April 29, 2022

Nilo Salgado Fernández  
Senior Traffic Engineer  
City of Albuquerque Planning Department

RE: Little Stars Daycare – TCL Revision 1

TCLIO

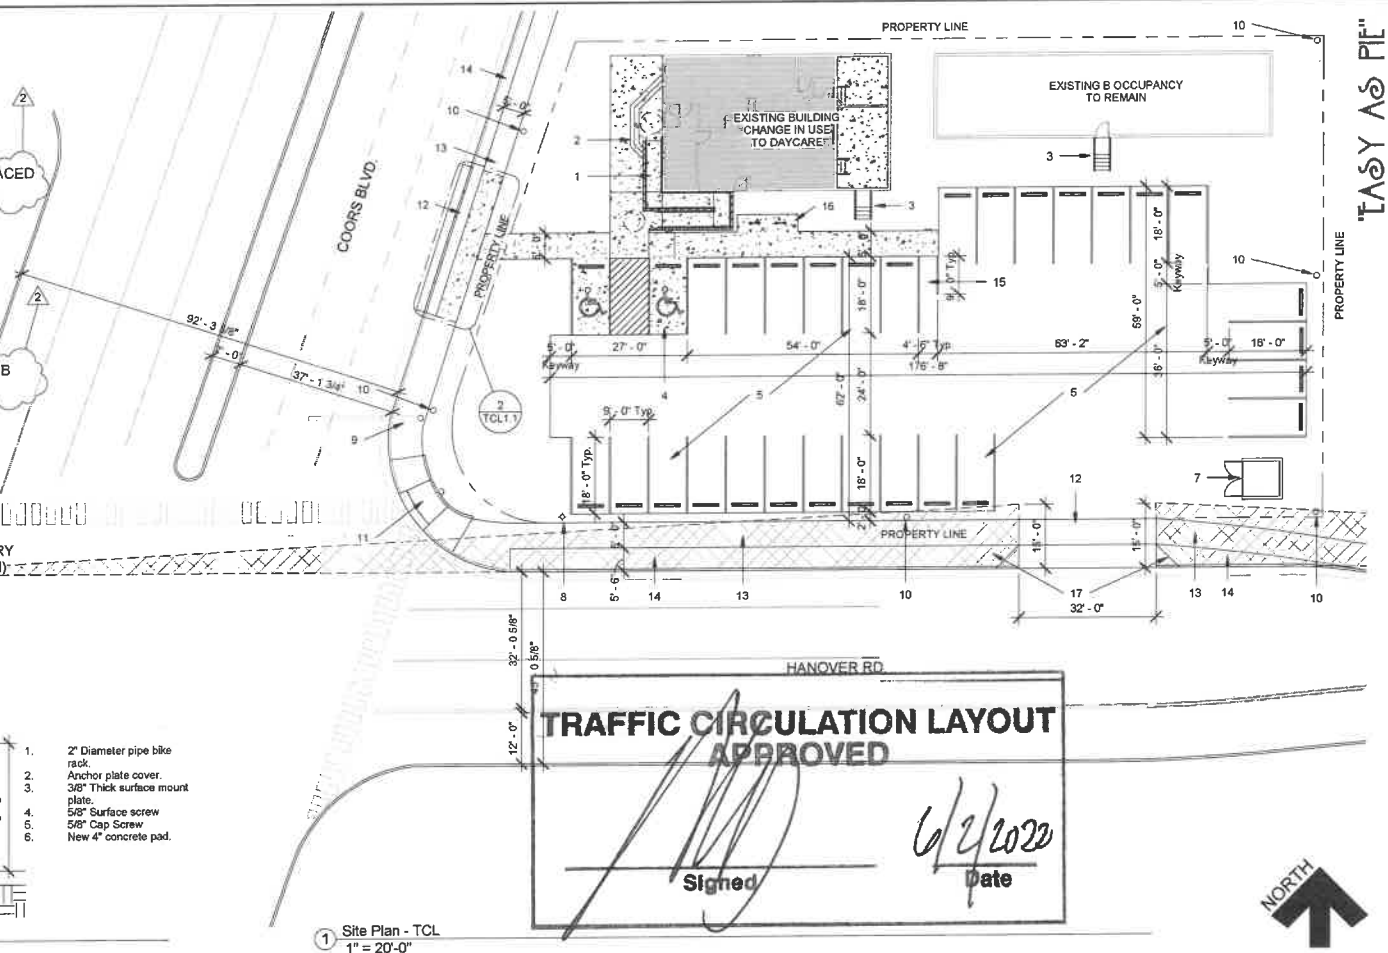
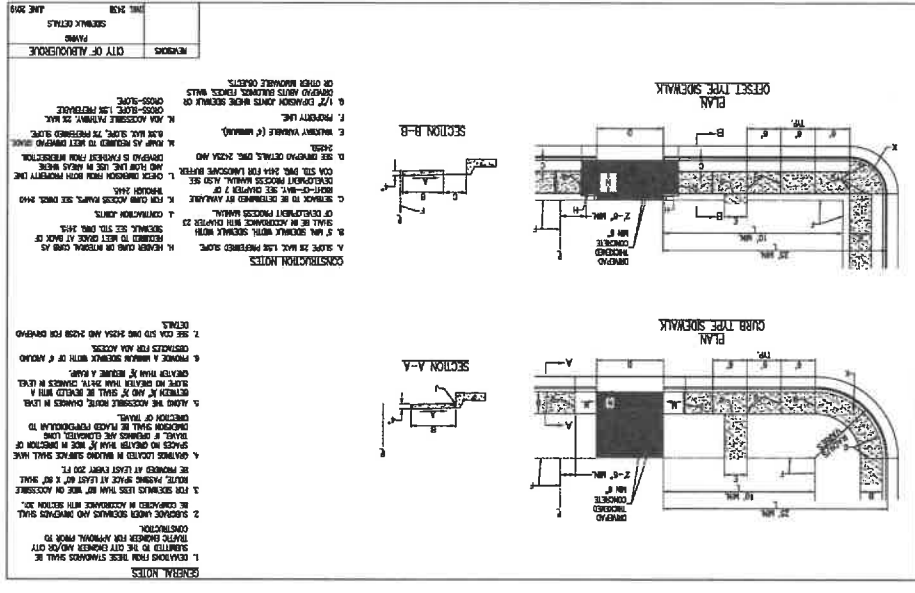
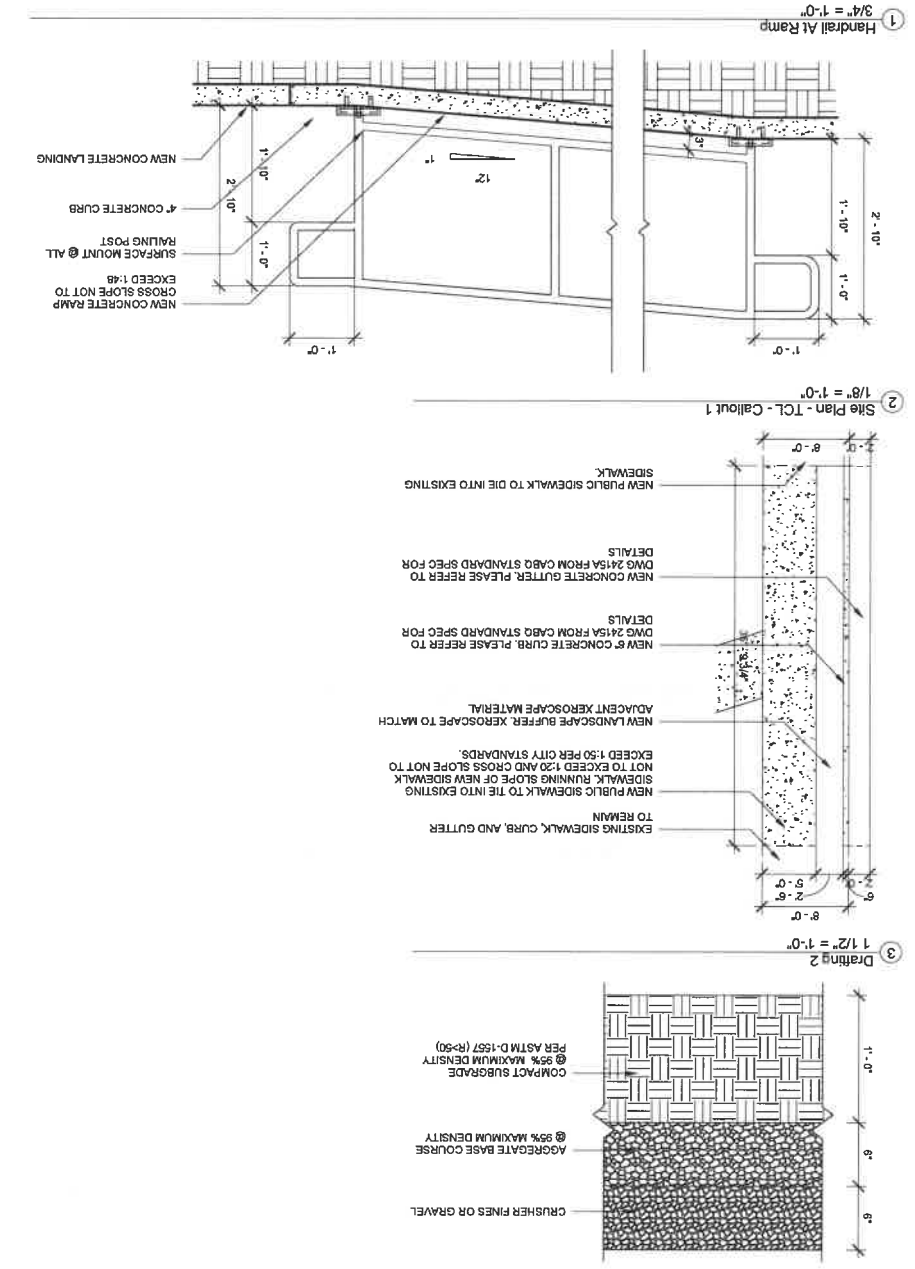
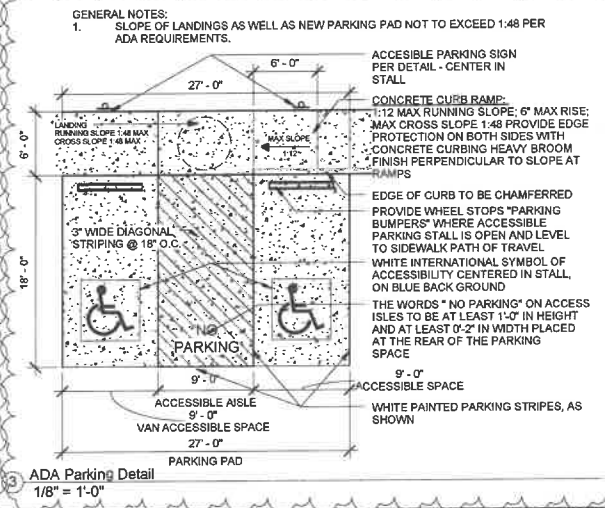
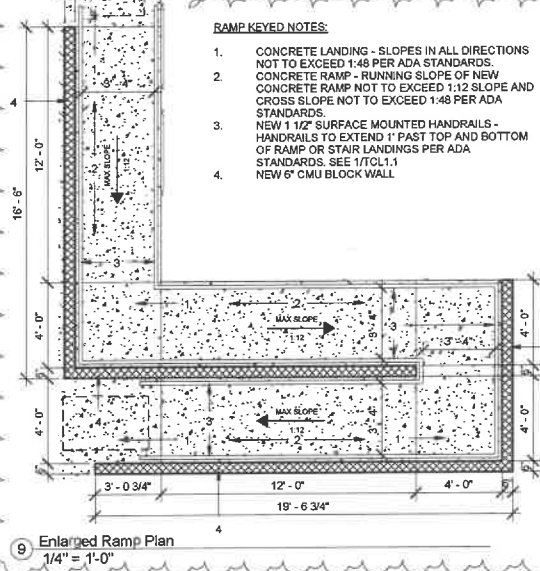
3. Hanover existing Public Sidewalk: It appears, from you design, a partial width of sidewalk is located outside of public ROW. This will require a Sidewalk Easement. *Property line was modified and corrected to be outside of the ROW.*

4. Keyed Note 1: The existing land and ramp will need to comply with the most current updated ADA accessibility requirements. Please verify this is the cause. *A concrete ramp that meets ADA requirements was designed and added to the drawings.*

5. Keyed Note 3: Reference sheet for location of detail. You just have XXXx for sheet number. *The placeholder of xxxx was corrected throughout the attached TCL and provided the proper detail reference.*

6. Keyed Note 11:
  - Drive pad will need to be current updated ADA accessible and it appears that this existing drive pad condition is not. Please provide a more current design. *The existing drive pad off Hanover does appear to be accessible. It has a flat 5' surface throughout the length and beyond the drive pad.*

- Your note is confusing since the drive pad is located on Hanover but the note specifies Coors. Please clear up this note. *There is an existing drive pad off of Coors that is blocked and not accessible. I was just calling it out as an existing condition.*

7. All existing public sidewalk: Provide existing widths. *The drawing was corrected to include*

- dimensions of existing sidewalks.
8. Private sidewalk dimensions: Some dimensions are not shown on layout. Please provide dimensions. **Dimensions were provided of new sidewalks in drawings.**

9. Detail 3: **Please see added notes of running slope and cross slopes on parking pad as well as landings.**
    - Where is your 50:1 max landing. Please label on detail.

- Shown is 12:1 max but on TCL layout it needs to be shown.
  10. Keyed Notes: All references need to be provided or take out the XXX and call out this sheet. **The placeholder of xxxx was corrected throughout the attached TCL and provided the proper detail reference.**

12. Identify the right of way width, medians, curb cuts, and street widths Coors and Hanover. **The widths of streets, medians have been labeled and identified.**

13. Maximum access width for arterial, collector, and local streets are as follows:
  14. Provide existing drive pad width (Not shown). **Drawings were corrected to include drive pad widths.**

15. Please list the width and length for all existing and proposed parking spaces. Some dimensions are not shown. **Typical dimensions were added to a few parking stalls to meet requirement.**

22. A 5 ft. keyway is required for dead-end parking aisles. **A 5' keyway has been labeled and dimensioned on plan.**
  23. Per the DPM, a 6 ft. wide ADA accessible pedestrian pathway is required from the public sidewalk to the building entrances. Please clearly show this pathway and provide details. **Please see noted dimension at new sidewalk. Also, see new ADA ramp leading to building**

- entry.
24. Per DPM, a 6 ft. wide ADA accessible pedestrian pathway is required from the ADA parking stall access aisles to the building entrances. Please clearly show this pathway and provide details. **Please see noted dimension at new sidewalk. Also, see new ADA ramp leading to building entry.**

27. Please provide a sight distance exhibit. **Please see added sight triangle.**
  28. Show the clear sight triangle and add the following note to the plan: "Landscaping and signage will not interfere with clear sight requirements. Therefore, signs, walls, trees, and shrubbery between 3 and 8 feet tall (as measured from the gutter pan) will not be acceptable in the clear sight triangle. **Please see added sight triangle and added note.**
